Our Ref: 21101

25 January 2022

**RE: REDEVELOPMENT OF PRESIDENT PRIVATE HOSPITAL (SSD-10320)
PEER REVIEW OF TRAFFIC & TRANSPORT ASSESSMENT**

On behalf of the Department of Planning, Industry & Environment (DPIE), The Transport Planning Partnership (TPPP) has undertaken a peer review of the traffic and transport assessment submitted with the State-Significant Development application (SSD-10320) for the proposed redevelopment of the President Private Hospital in Kirrawee.

West Carpark Detail Plan

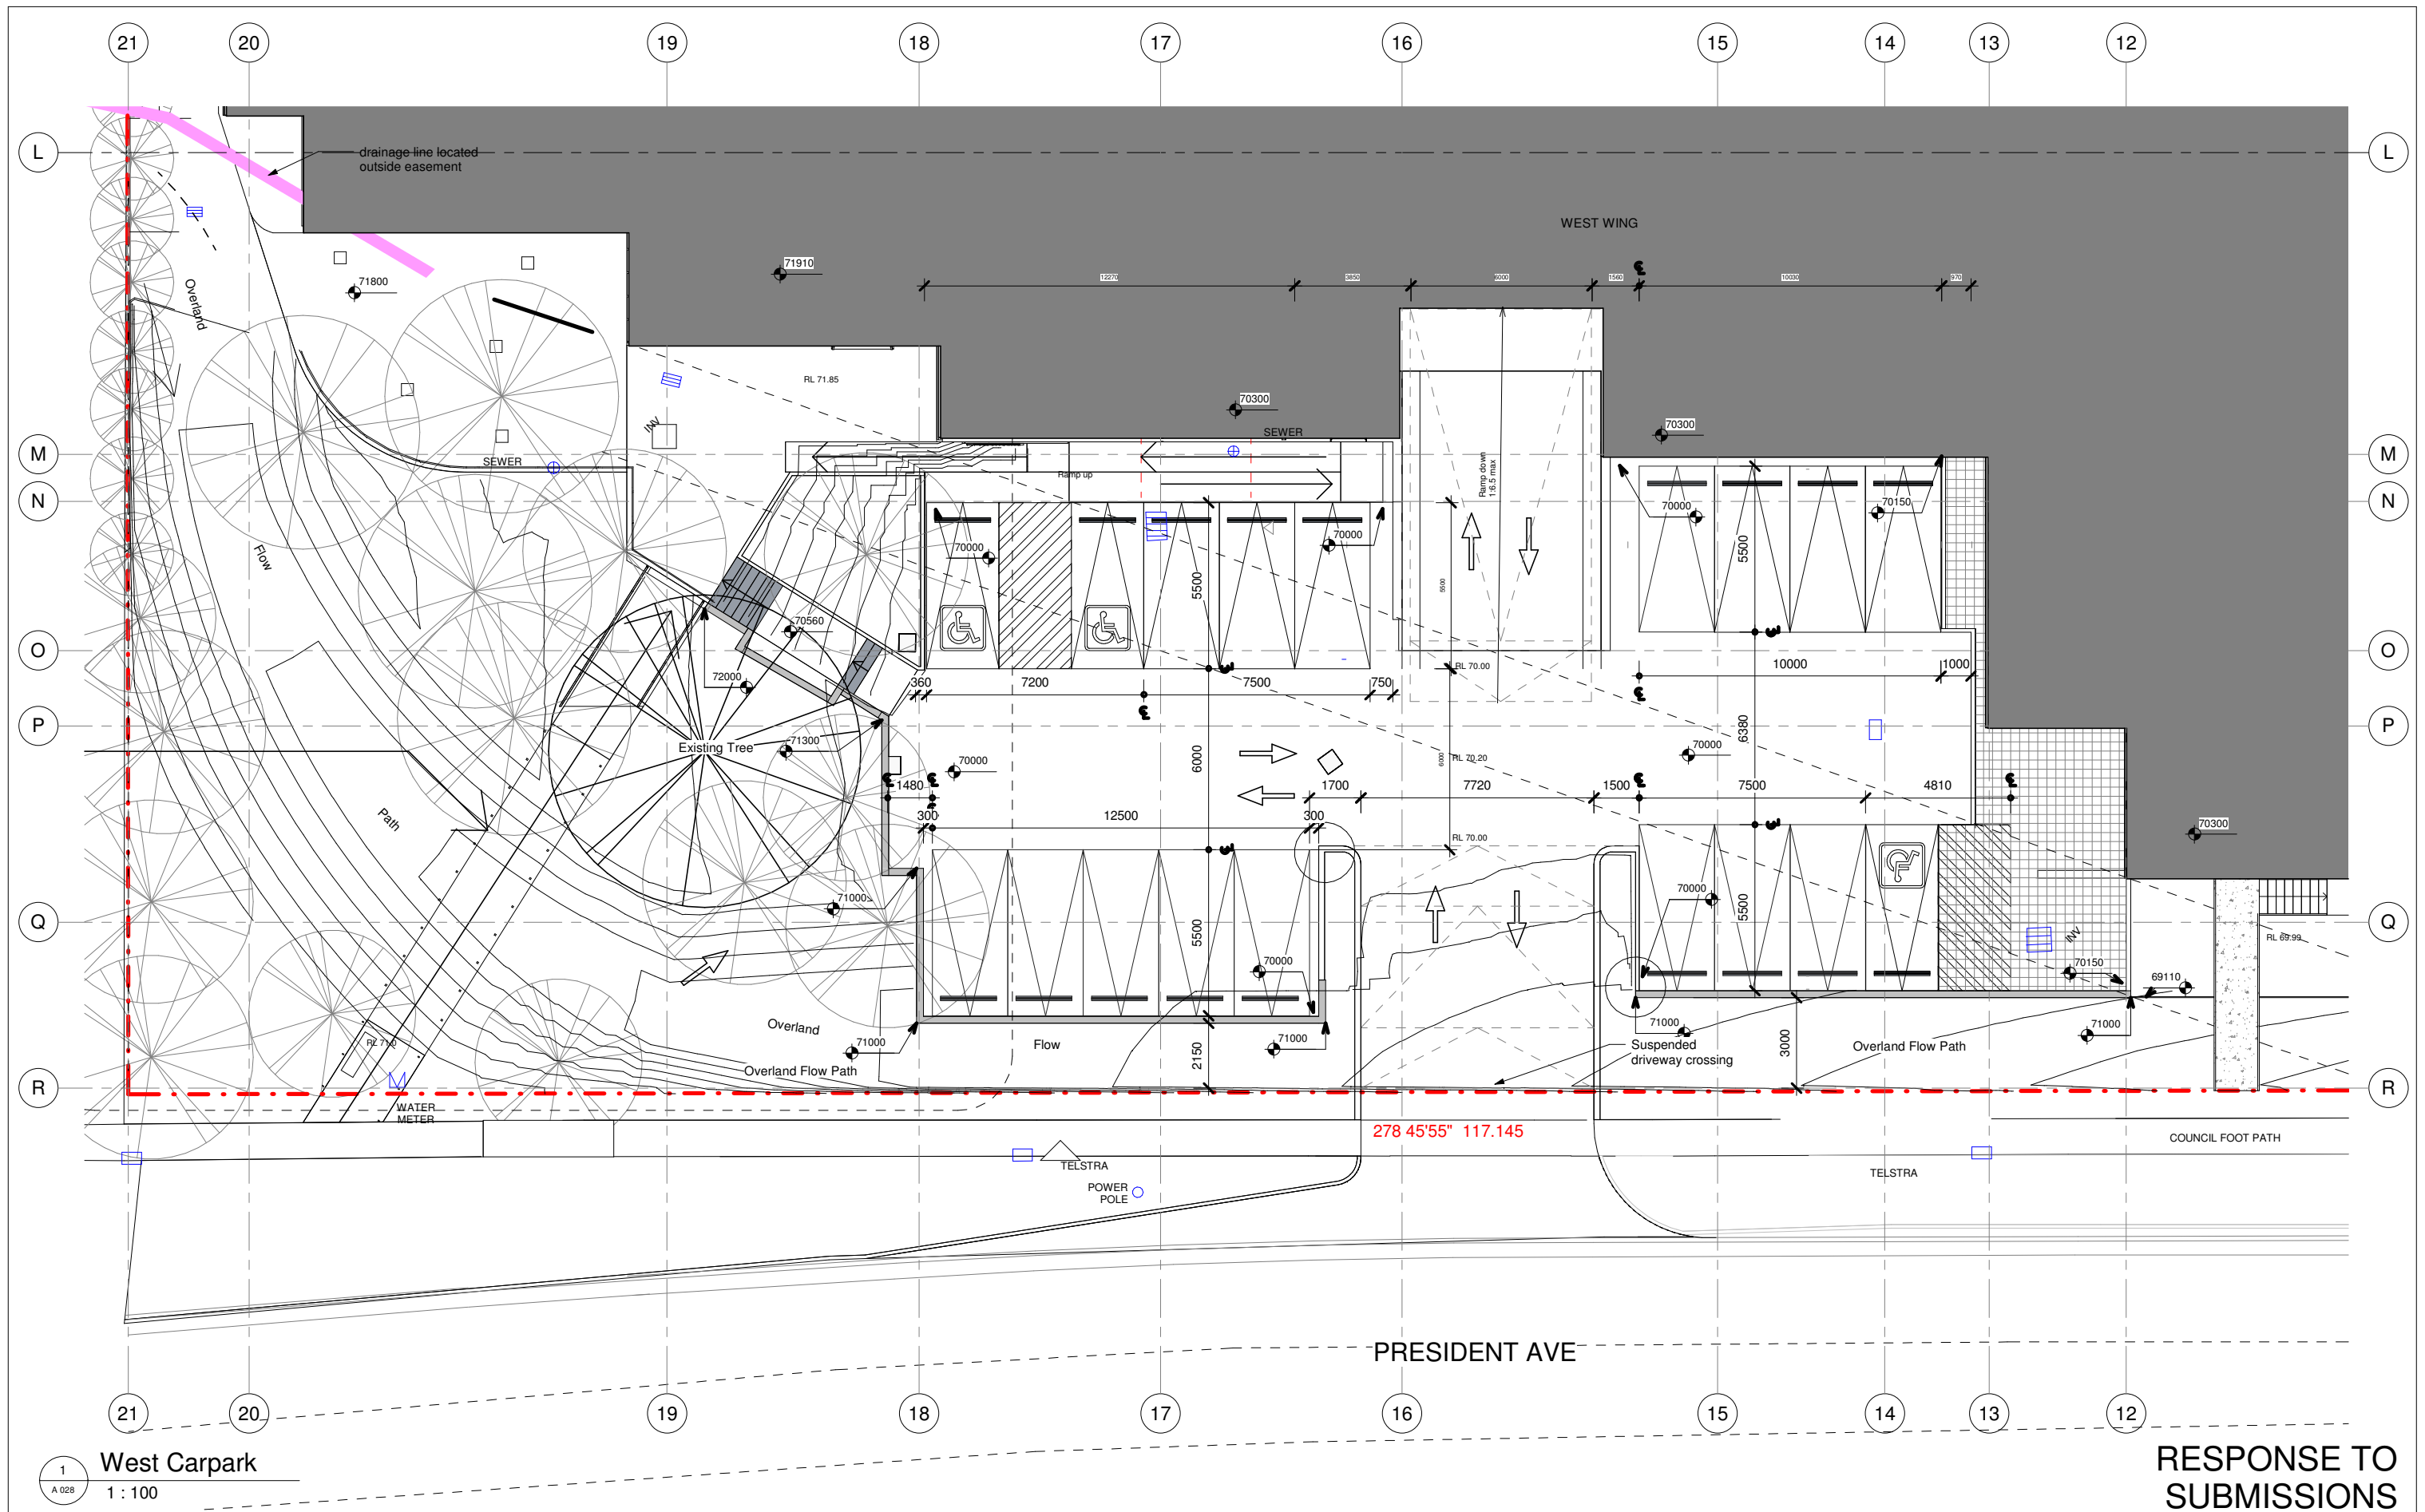
ML Traffic Engineers assesses that the car park fronting President Avenue has an existing supply of 20 spaces for patients. From site observations, the car park has no line marking and hence it cannot be formally understood to have a supply of 20 spaces. In addition, the parking survey undertaken by the proponent shows that the car park is occupied with 15 – 16 spaces through a typical weekday (9:00am – 3:00pm). Although there may be a theoretical maximum of 20 car parking spaces, this may be contingent on patient/ visitor parking behaviour and not formally recognised without line marking for guidance.
